CITY OF ALBUQUERQUE

Re: TOWNEPLACE SITES BY-MARRIOTT

Grading and Drainage Plan

Engineer's Stamp dated 5-13-2011 (F17/D072A)

GRADING AND DRAINAGE PLAN

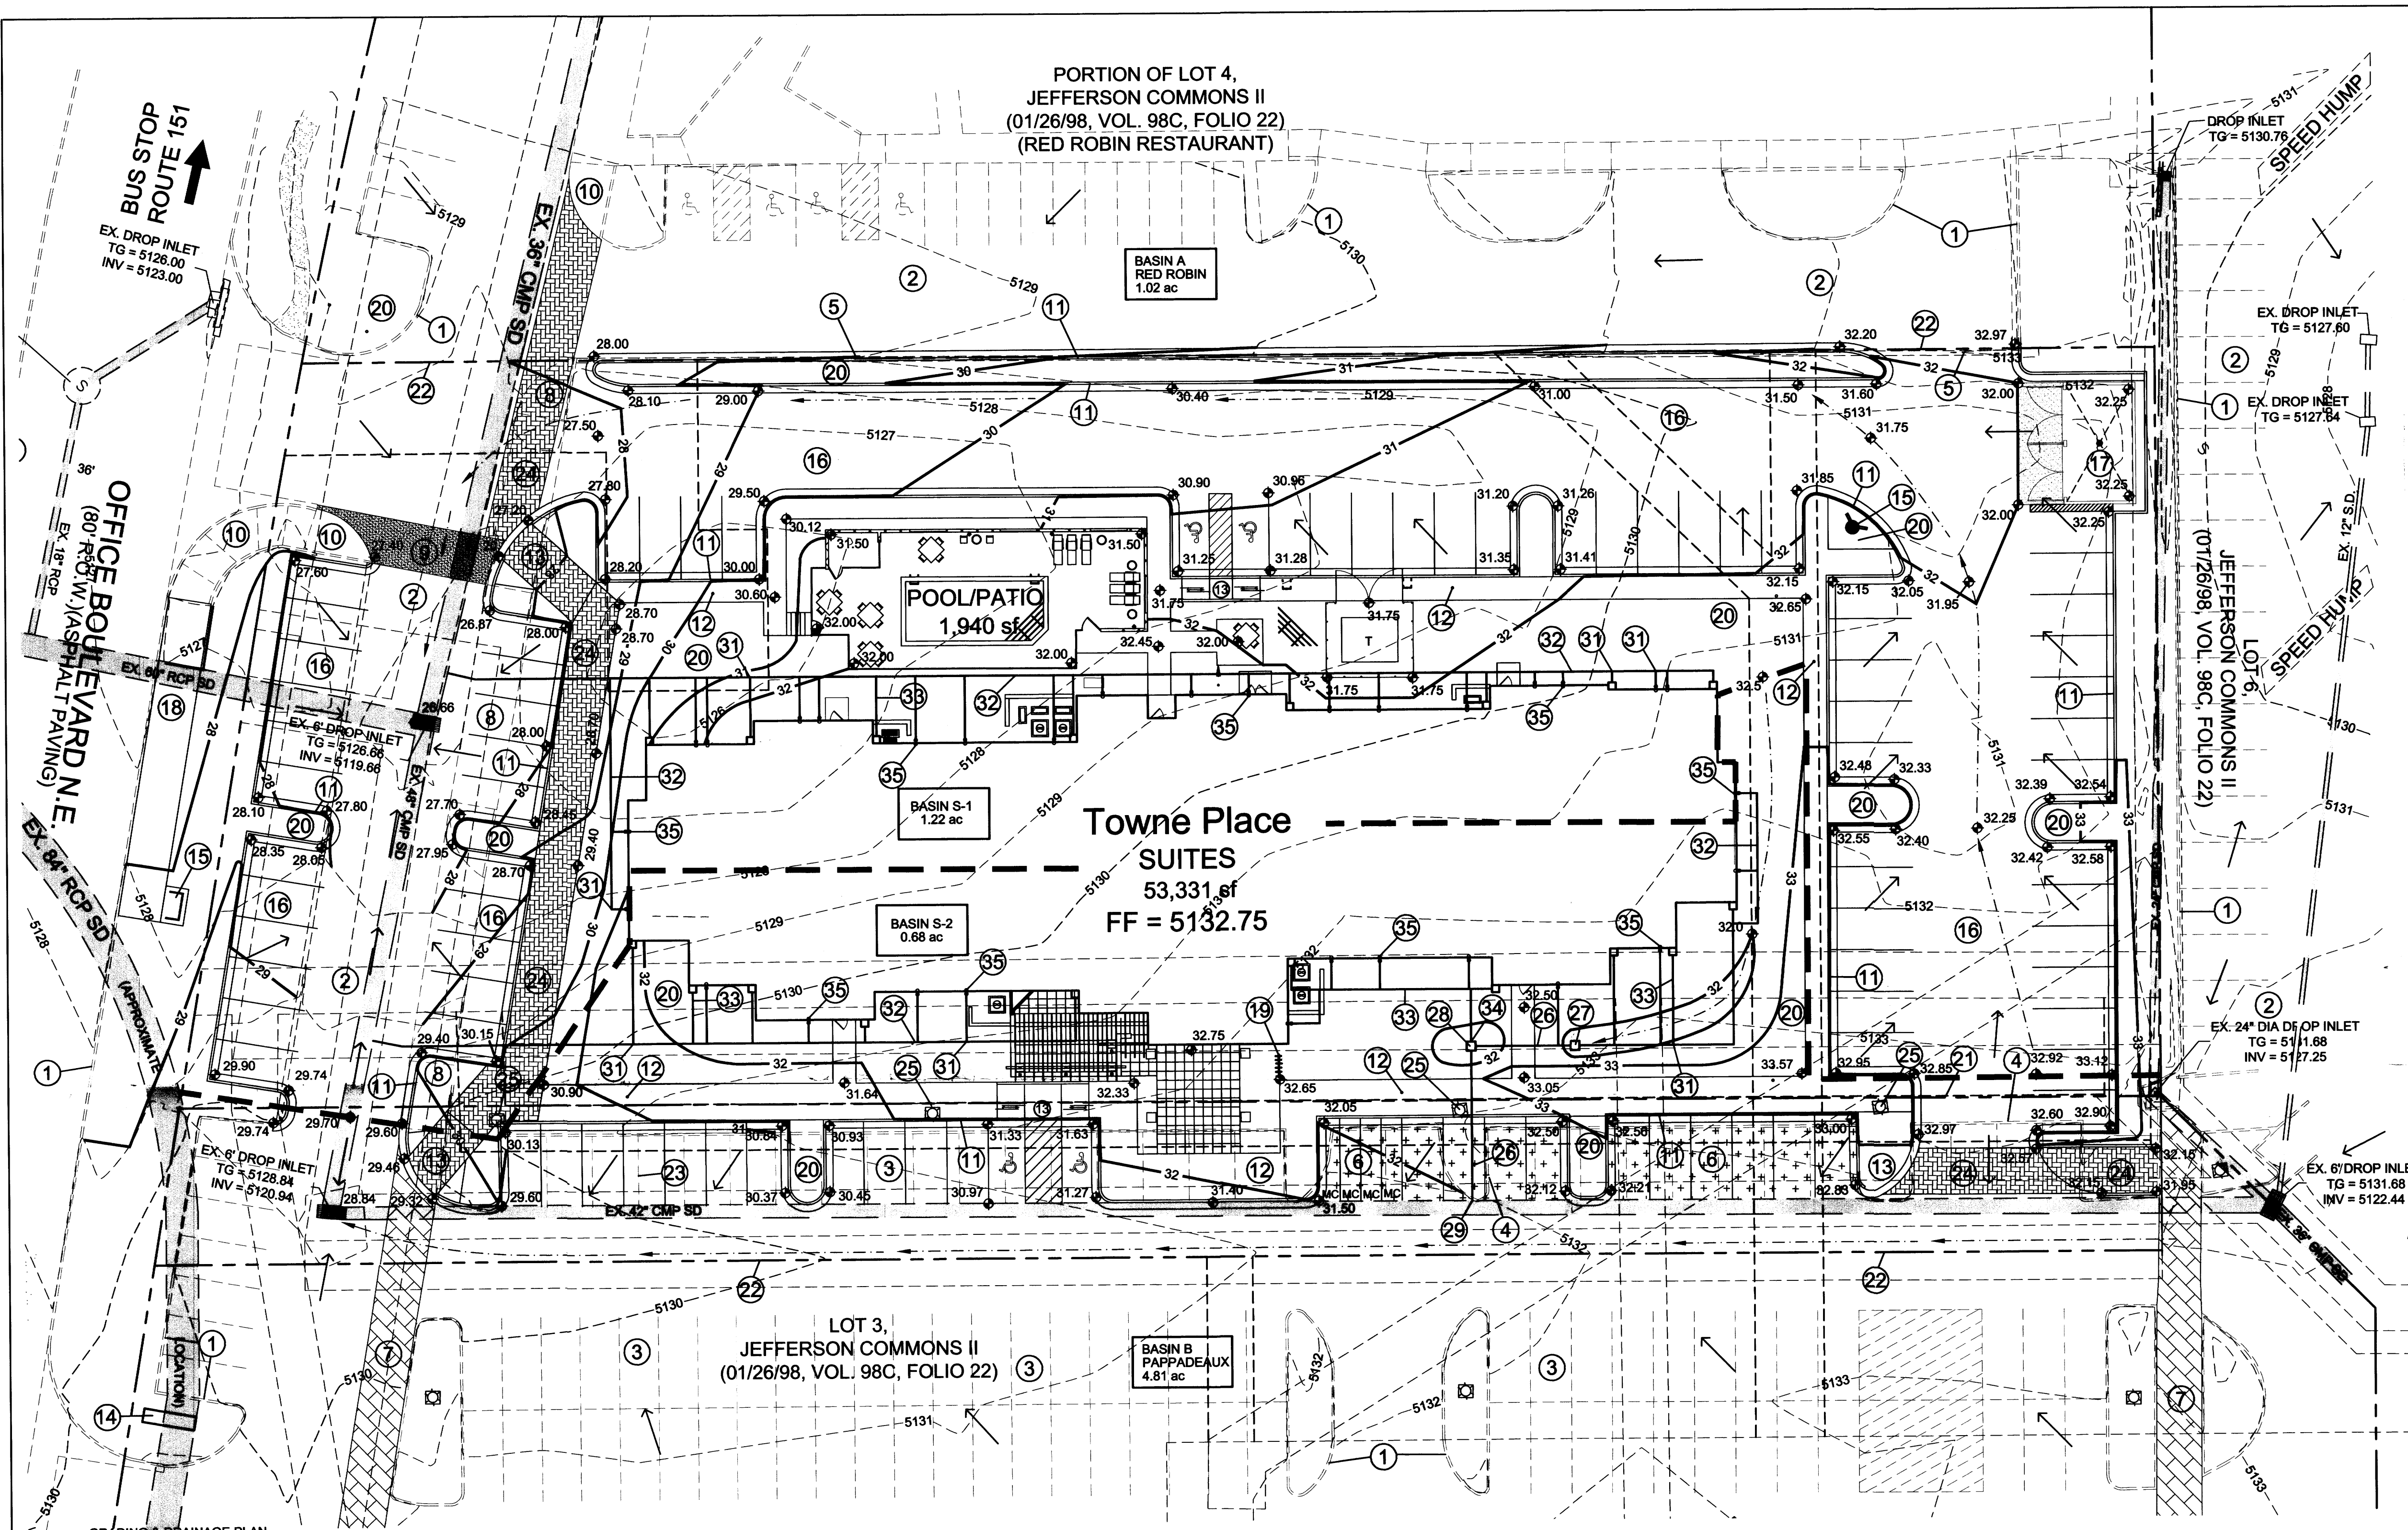
- Hydrology is requesting that proposed landscape areas be depressed to retain/infiltrate the rain that falls on them.
